Recommendation Report for Planning Permission for Works or Extension to a Dwelling

REF NO: CM/5/22/HH

LOCATION: 28 May Close
Climping
BN17 5TF

PROPOSAL: Erection of first floor side extension.

PROPOSED FIRST FLOOR - SCALE 1:50

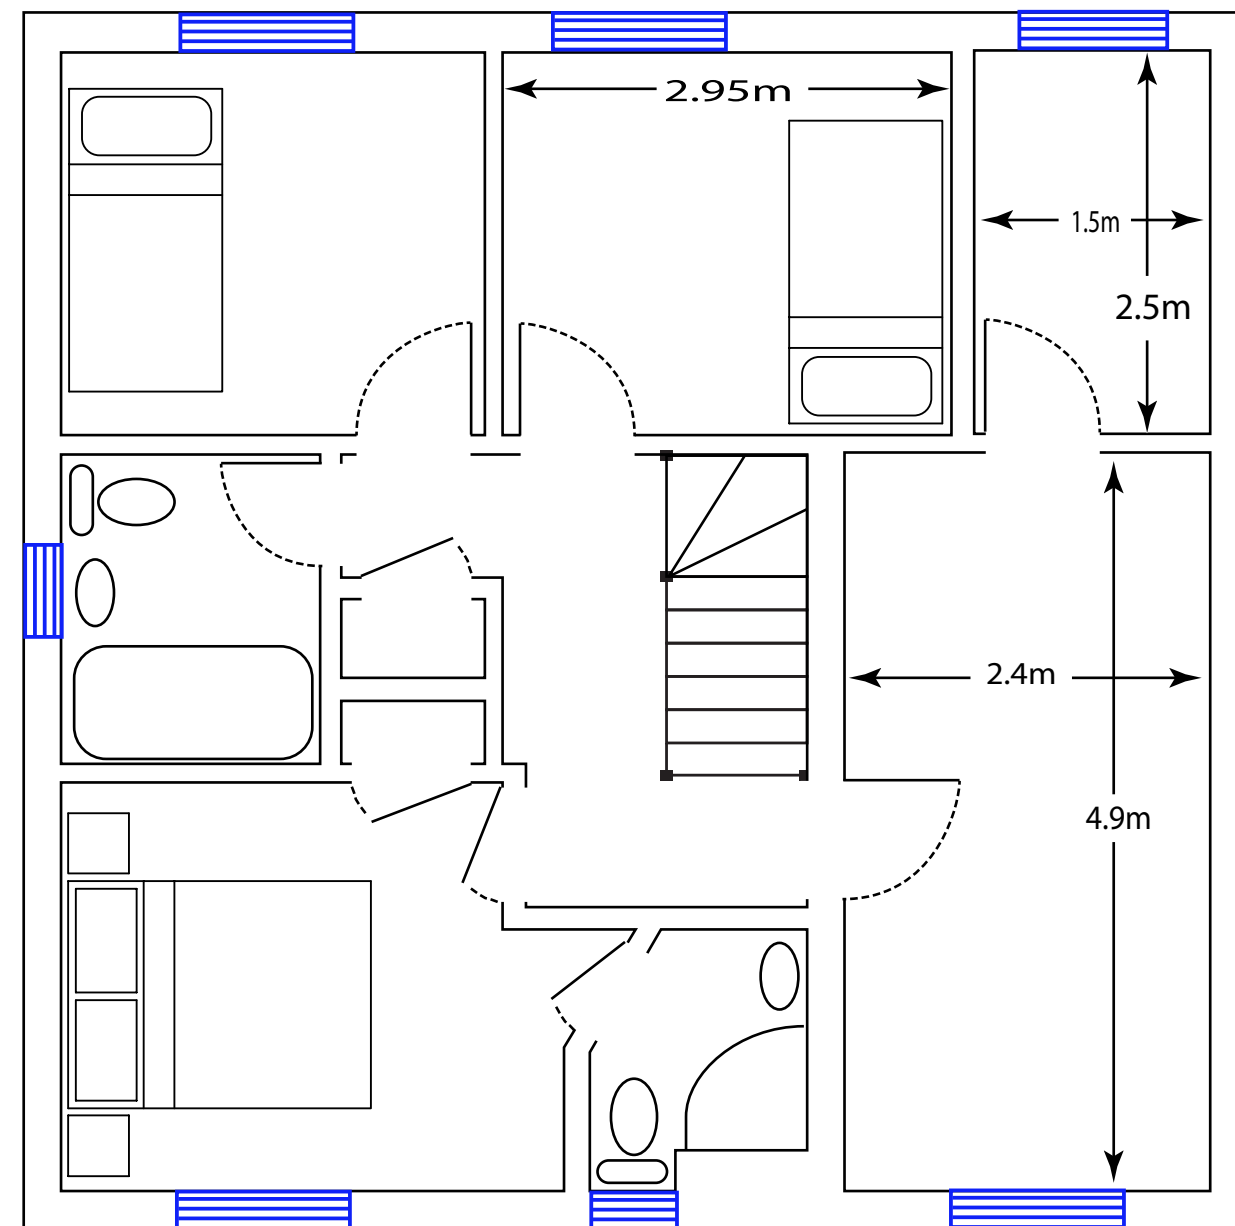
The proposal includes the installation of 2 No. windows, one to the front of the property and one to the rear. The new front window is on the first floor and looks out onto the street and gives no rise to adverse impacts by way of overlooking. The new rear window is on the first floor looking out to the rear garden. This rear window does not give rise to significant adverse impacts by way of overlooking.

PROPOSED ELEVATIONS. SCALE 1:100

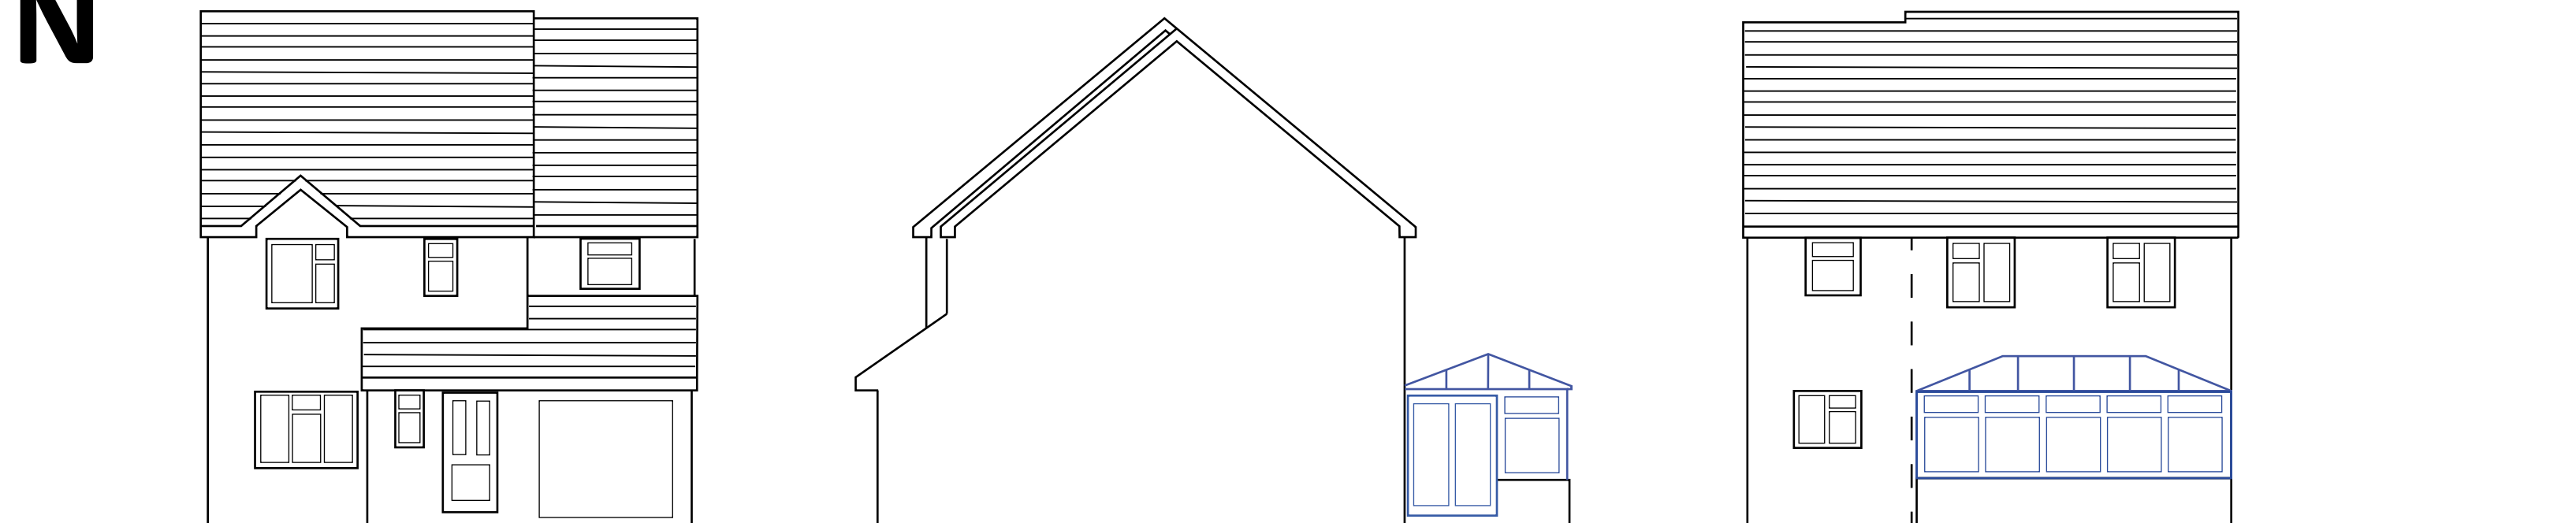
The proposal reaches a height of approx. 8.5m sitting approx. 0.1m below the peak of the host dwellings ridge line. Section M of the Arun Design Guide proposes that side extensions at the first floor should be set back by approx. 2m from the front elevation and a minimum of 0.5m below the ridge line. This proposal is set back approx. 1.2m from the front elevation and as such, this proposal does not comply with Section M of the Arun Design Guide in either of these cases. However, due to a well integrated visual design, moderate scale and many similar designs within the locality, the proposal is acceptable and is considered visually subservient to the host dwelling. Additionally, the materials proposed are matching to those found on the existing dwelling and within the locality. This extension would be a prominent change in the street scene however, there are many examples of similar first floor designs on the street and within the locality including the neighbour dwelling to the north (No. 29 May Close). Therefore, the proposal is in character with the locality and will not give rise to any significant adverse visual impacts on the street scene.

The proposal will almost mirror the southern elevation of the neighbour dwelling to the north (No.29 May Close) however, it is set back further by approx. 1.2m. Section M of the Arun Design Guide sets out the 45 degree rules when concerning amenity impacts. This proposal does not intersect rear 45 degree sightlines and due to the siting of the proposal, it is not considered to have any significantly adverse impacts by overshadowing despite intersecting the 45 degree light accessibility lines.
